CITY OF ALBUQUERQUE

Re: AHJ Capital LLC
4401 Montano Rd. NW
30-Day Temporary Certificate of Occupancy- Transportation Development
Transportation Development Final Inspection
Architect's Stamp dated 31-3-16 (E12D010)
Certification dated 9-15-17

3 BIKE RACK

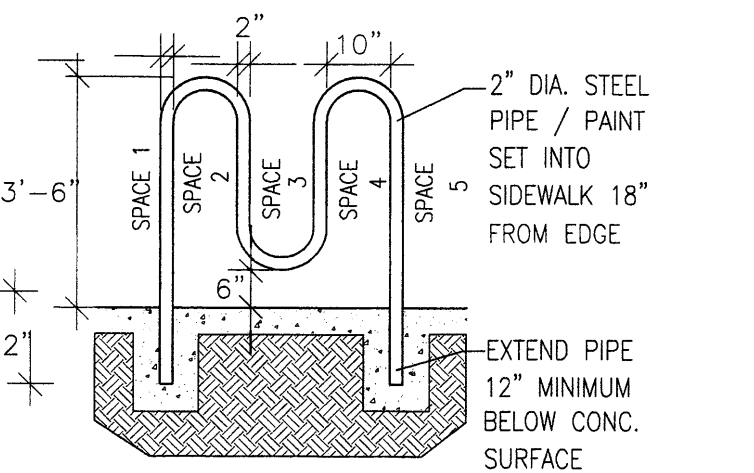
1. The proposed Bicycle Rack improvement have not been constructed per plan.
